CITY OF MERCER ISLAND

September 13, 2023

RE: SUB23-004 - Request for Information One – Design Built Homes two lot short subdivision.
4719 86th Avenue SE, Mercer Island WA 98040, King County Assessor tax parcel number: 7598100420

TITLE SHEET  
 4719 86TH AVENUE SE  
 MERCER ISLAND, WASHINGTON  
 PARCEL NO. 7598100420

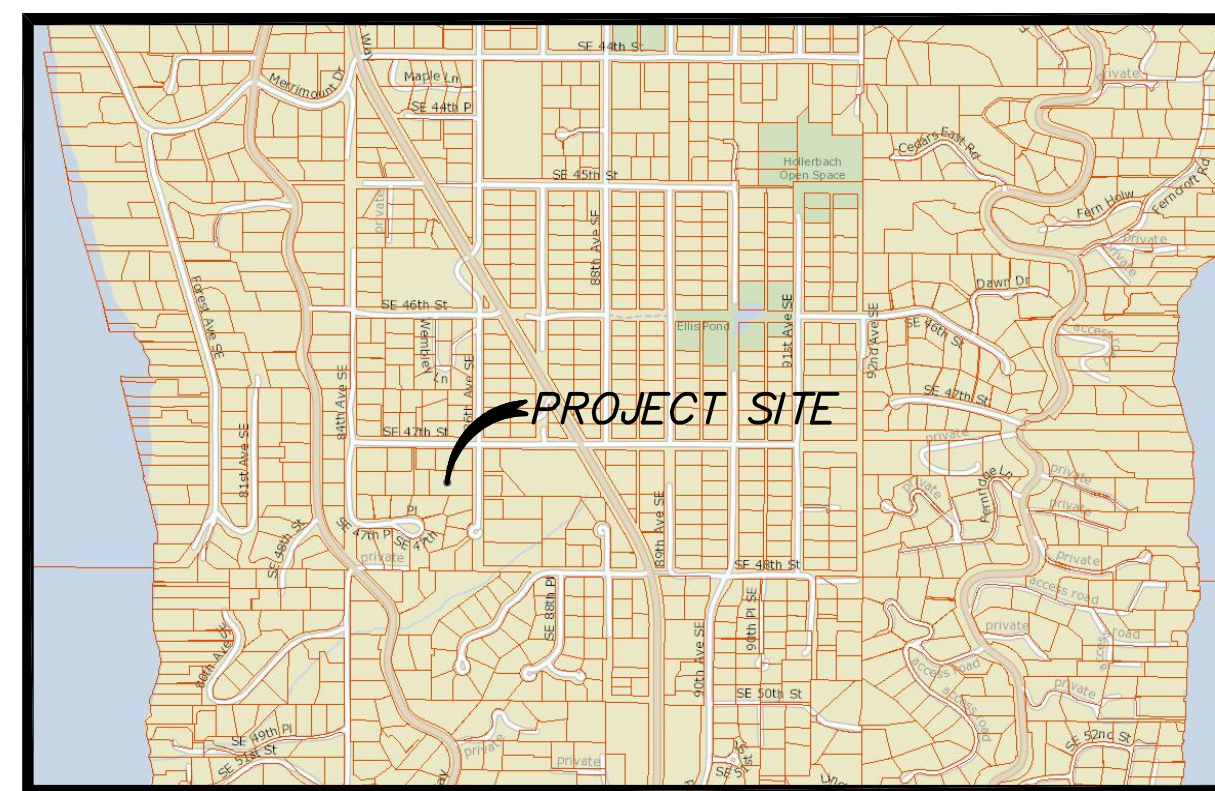
9. Plat Map Note- Please include this note on your plat map.

"All building permits are subject to meeting current fire code requirements at the time of a complete submittal, including fire apparatus access as outlined in adopted code sections of the International Fire Code Appendix D. Fire plan reviews will be conducted at time of building permit submittal and may require additional fire protection systems and/or additional fire prevention measures for building approval."

SITE PLAN

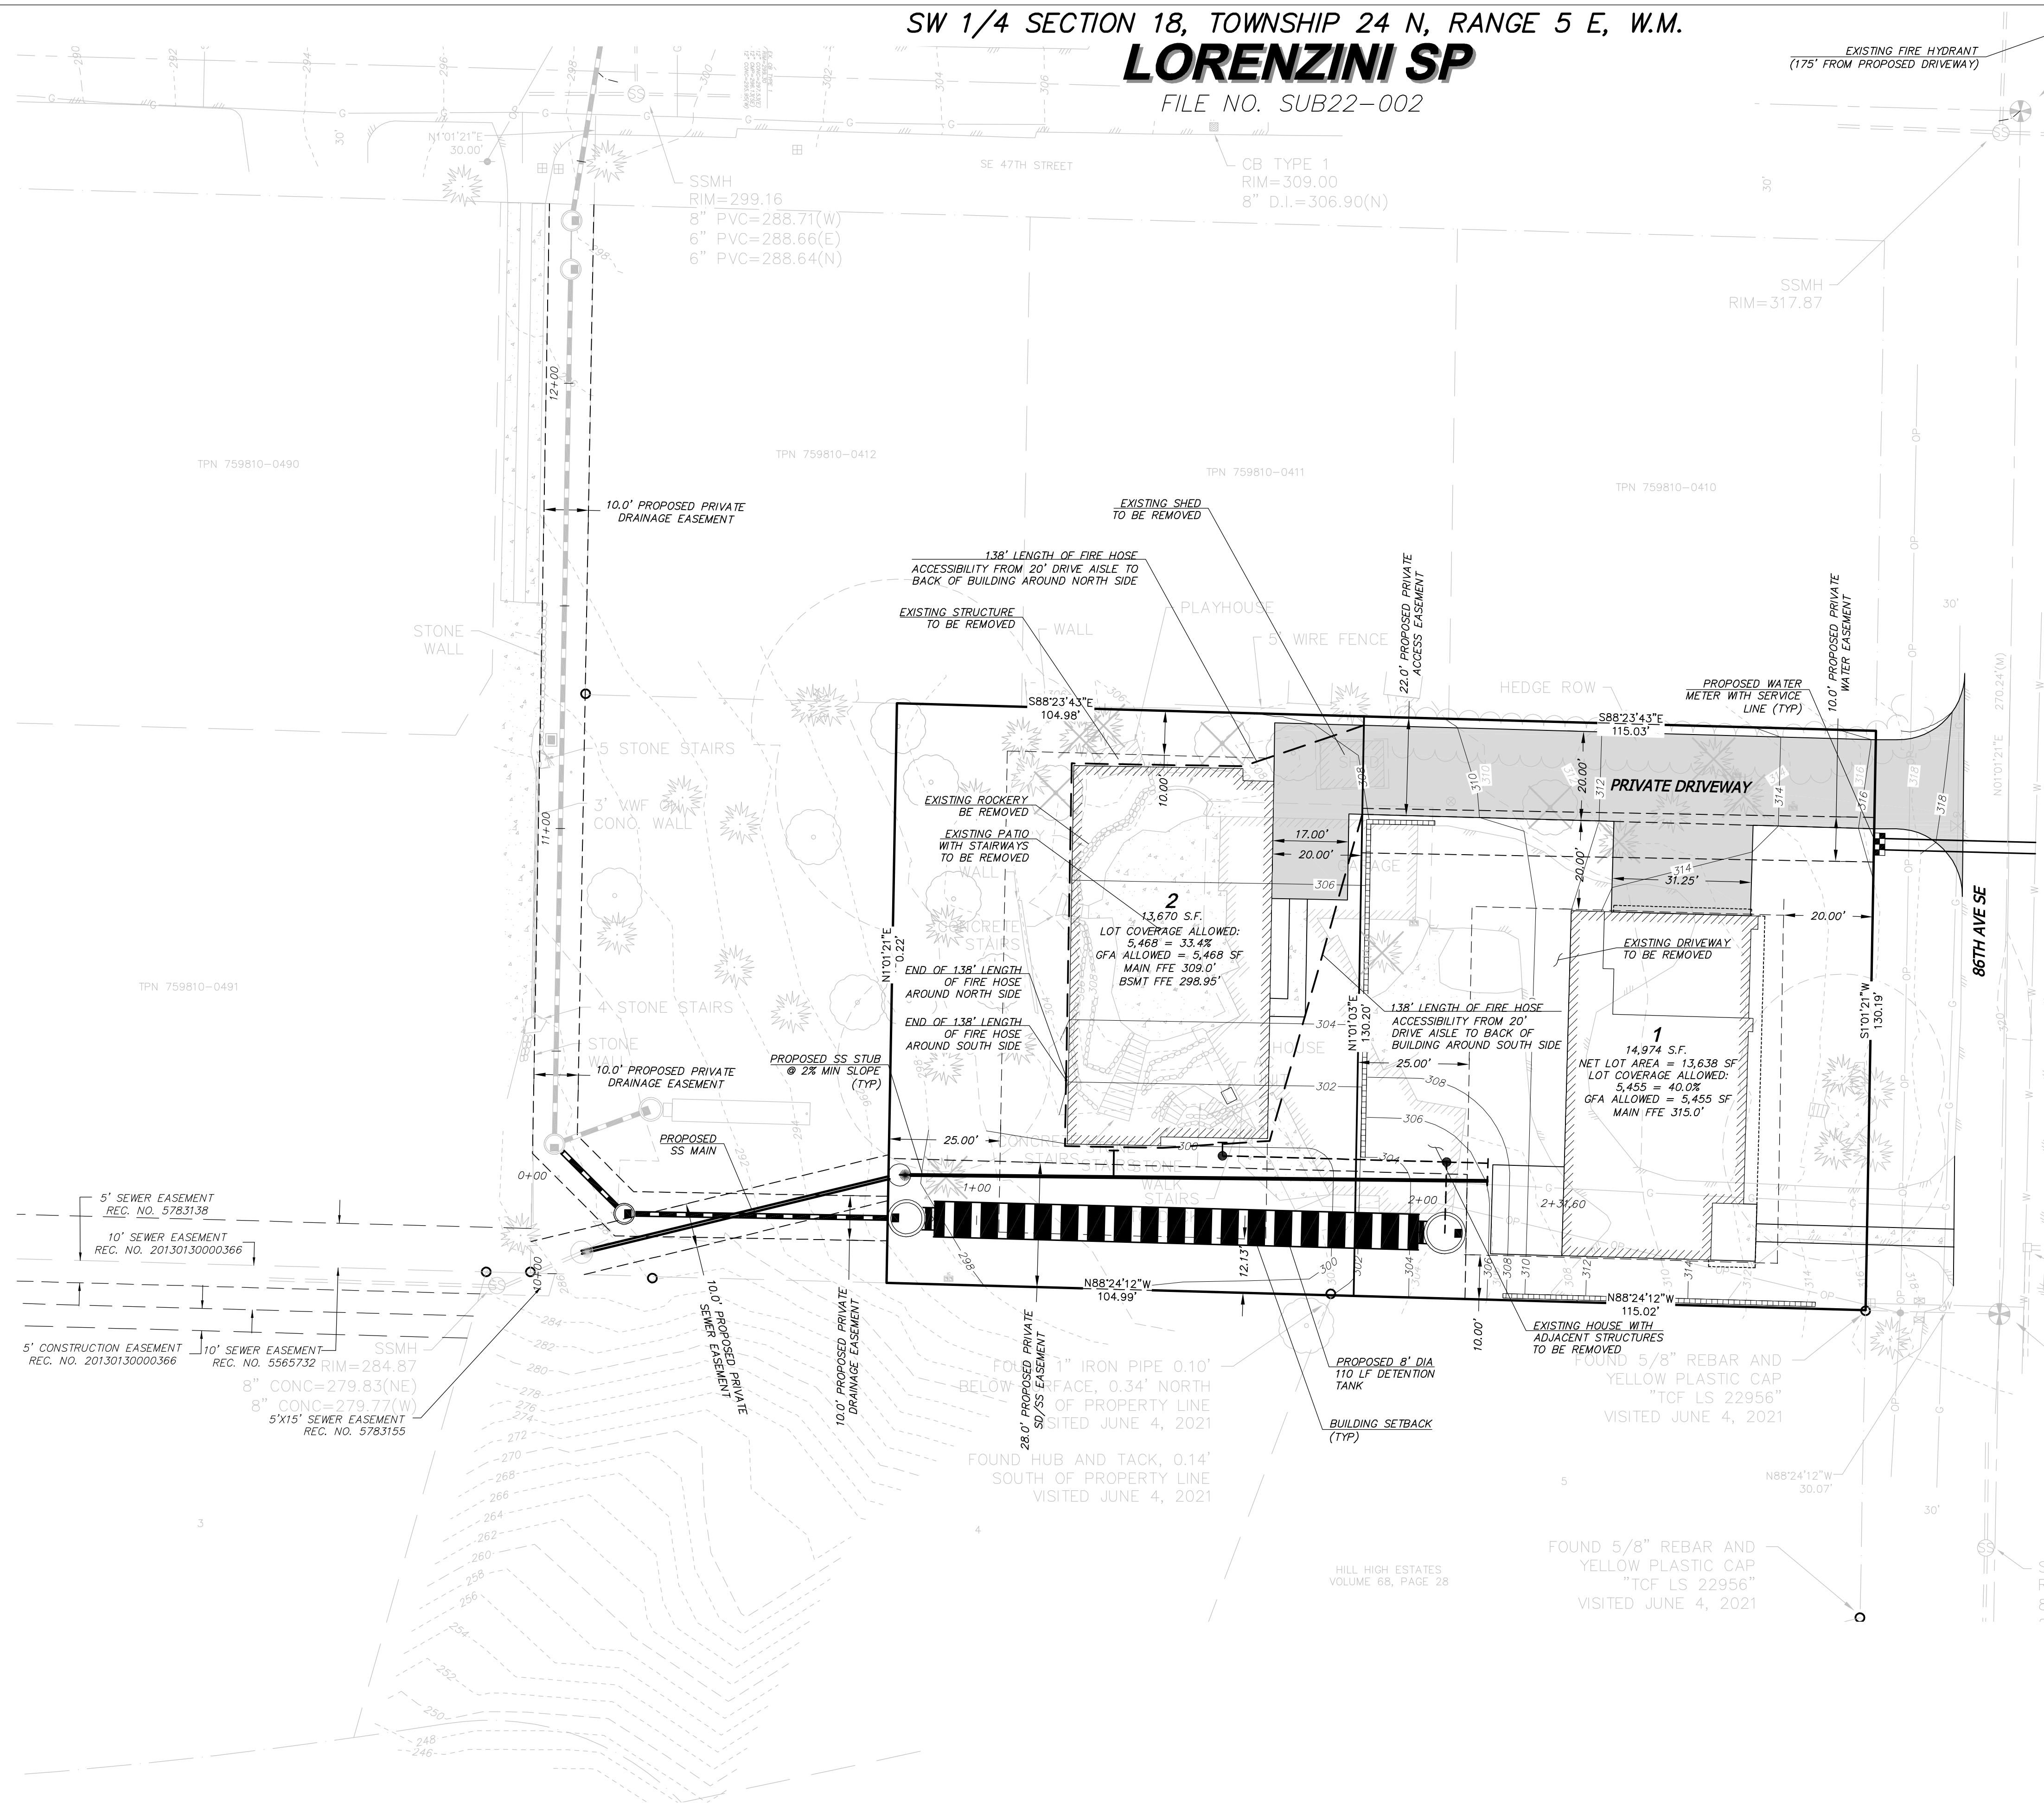
1. This short plat application involves work on and the creation of easements on an adjacent lot parcel number 759810-0421 which is not a part of this short application. please remove the proposed easements and proposed improvements from this short plat application.
